Your ref 3/2025/0196
Our ref DC/25/771
Date 14-APR-25

Location: Land off Longsight Road Langho bounded by the railway Northcote Park and Wildmans Farm,

Proposal: Outline planning application for up to 300 residential dwellings, associated access, rail station, car park, green infrastructure and sustainable drainage systems (all matters reserved except for access).

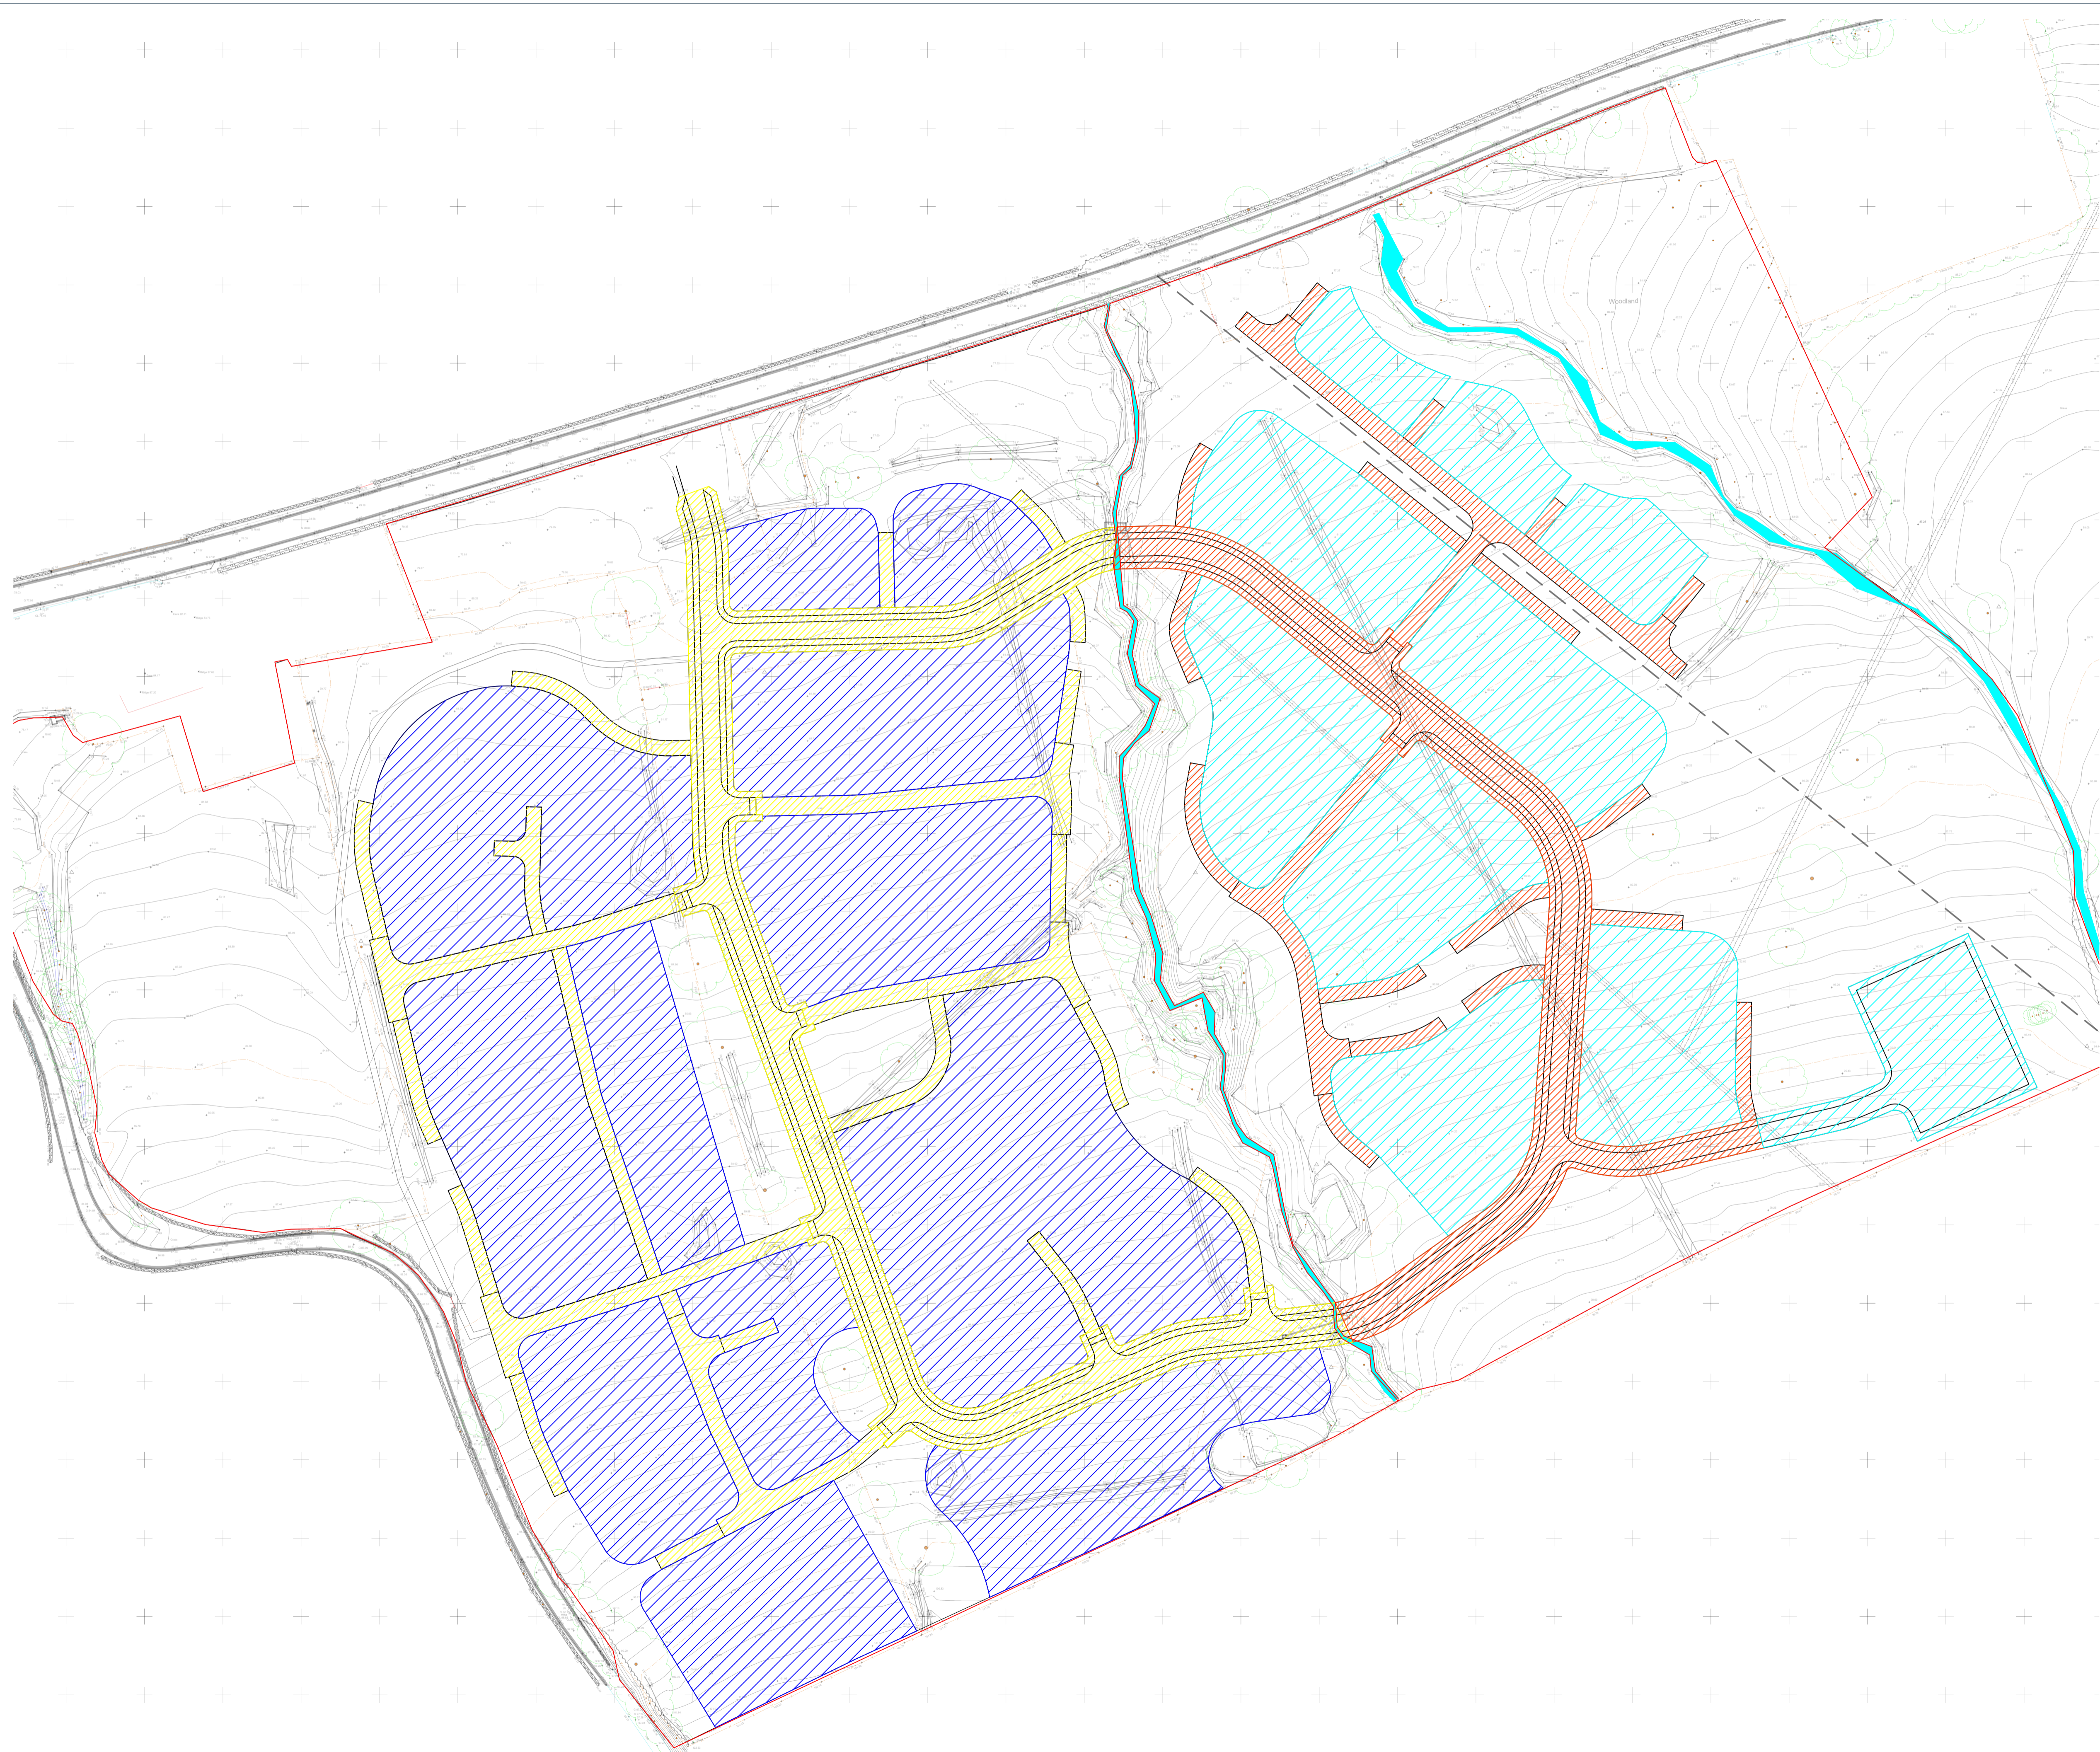
Following our review of the submitted drainage documents; Drainage Strategy Ref: 49343-ECE-XX-XX-DR--0003, Rev P03 Dated 26.02.2025, the drainage proposals are not acceptable to United Utilities. This is because we would expect to see finished floor levels on all dwellings as well as cover and invert levels of all manholes.

Prior to the commencement of development, details of a sustainable surface water drainage scheme and a foul water drainage scheme shall be submitted to and approved in writing by the Local Planning Authority. The drainage schemes must include:

- (ii) A restricted rate of discharge of surface water agreed with the local planning authority (if it is agreed that infiltration is discounted by the investigations);*
- (iii) Levels of the proposed drainage systems including proposed ground and finished floor levels in AOD;*
- (iv) Incorporate mitigation measures to manage the risk of sewer surcharge where applicable; and*
- (v) Foul and surface water shall drain on separate systems.*
